Rezoning Transportation Analysis

Petition Number: 2021-114

Date	Description
09-15-21	First Review (BKB)

DATE: 04/19/2021	MPIC: WILL
DRAWN BY: DSB	CHECKED BY: RAC
PROJECT NUMBER: 00867.00	
SCALE: 1" = 30'	
TITLE: CONCEPTUAL SITE PLAN

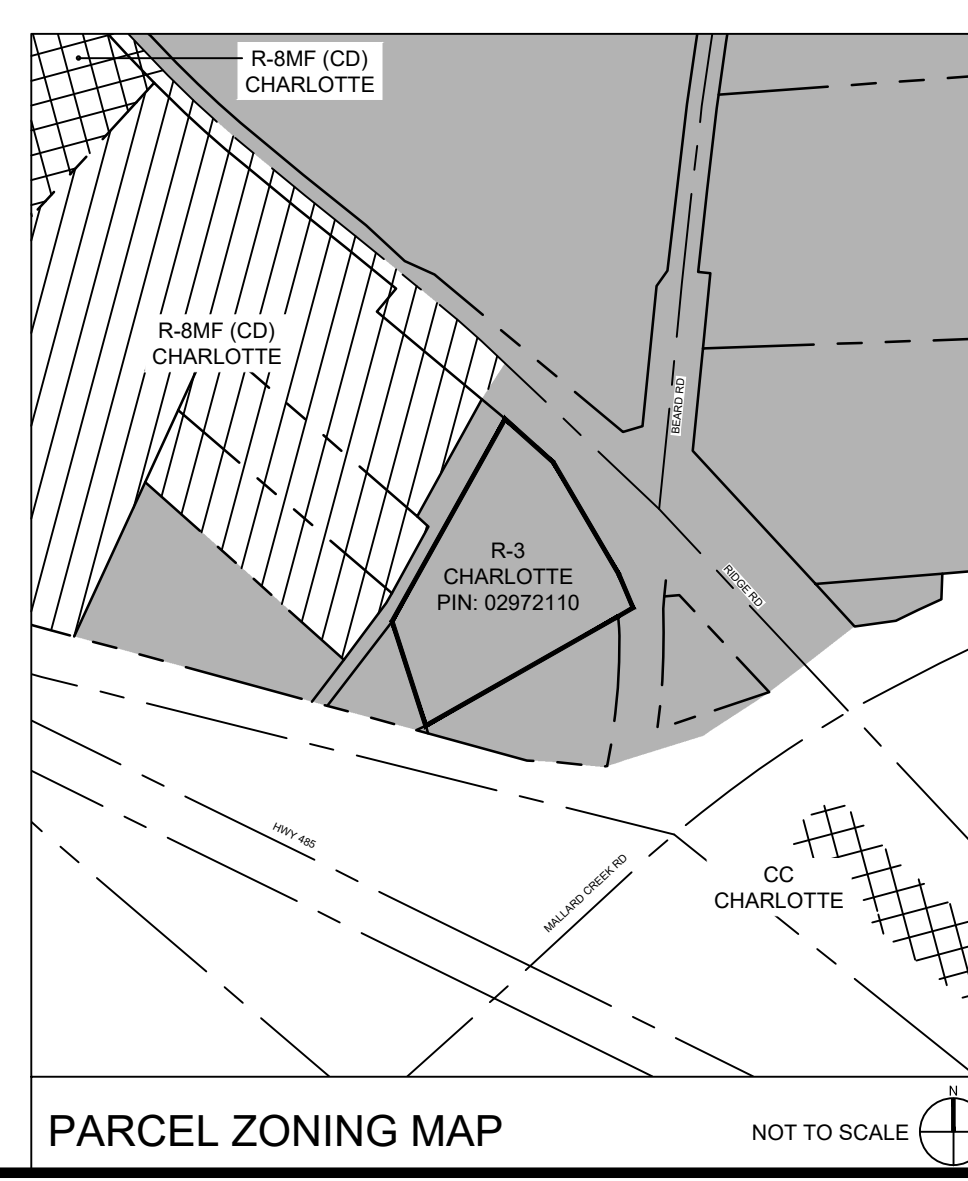
4. Site plan and revisions are needed to reflect the access point to the development on the western portion of the property per the below image. The existing Ridge Road and Beard Road intersection would require improvements that aren't commensurate with the development, so this relocated driveway will require less improvements of the developer within Ridge Road.

DATE: 04/19/2021 MPIC: WLL
DRAWN BY: DSB CHECKED BY: RAC
PROJECT NUMBER: 00867.00
SCALE: 1" = 30'
TITLE: TECHNICAL DATA PLAN
SHEET NO: RZ-1

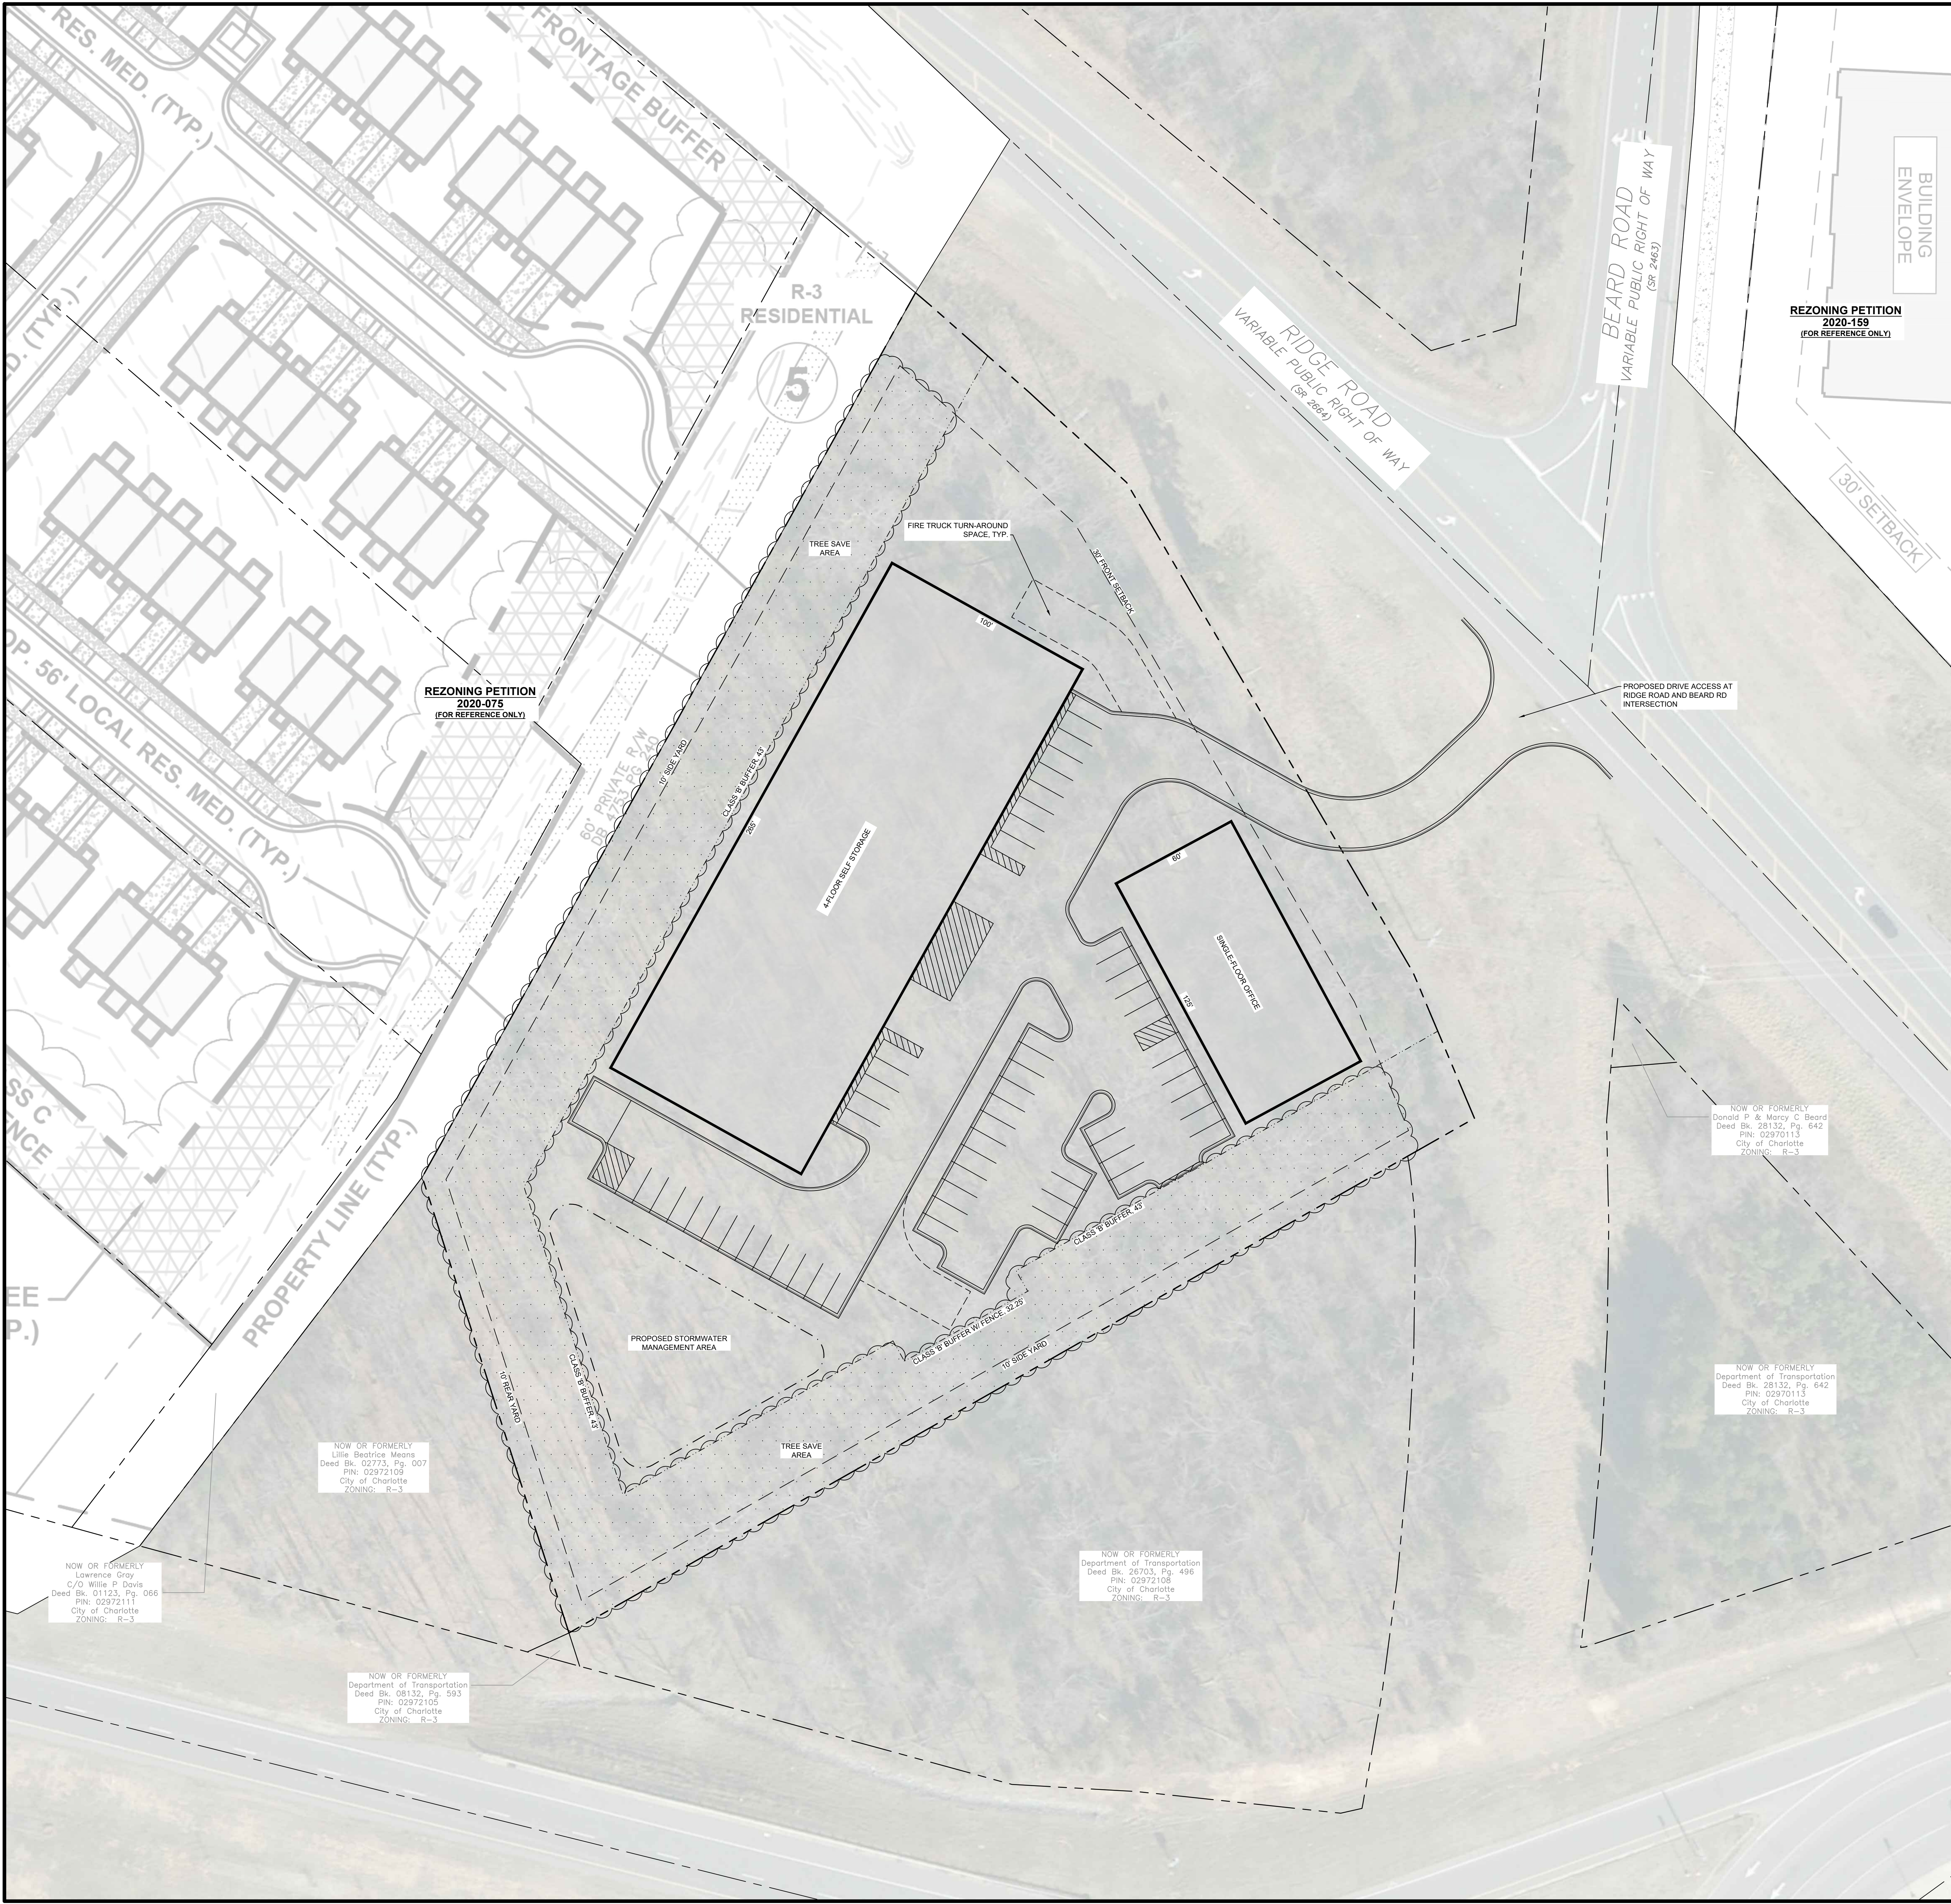
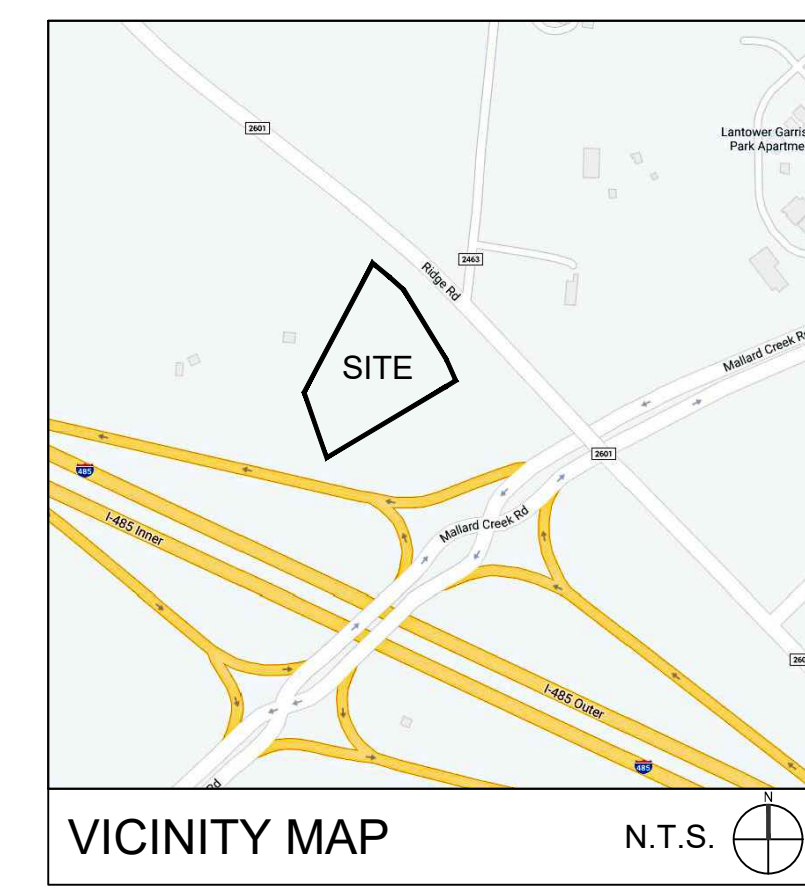
1. **Curblines:** The proposed zoning district has a setback measured from back of the existing or proposed future curblines.
 - a. **Ridge Road:** Provide curb and gutter along existing edge of travel lane along the entire property frontage. Use existing edge line for placement of gutter.

Label and dimension the curb and gutter from the centerline for Ridge Road on the site plan.

3. Revise site plan and conditional note(s) to commit to construct an 8-foot planting strip, curb and gutter, and 10-foot sidewalk on Ridge Road per Chapter 19. The site plan shall label and dimension both items from the back of curb and gutter and road centerline.
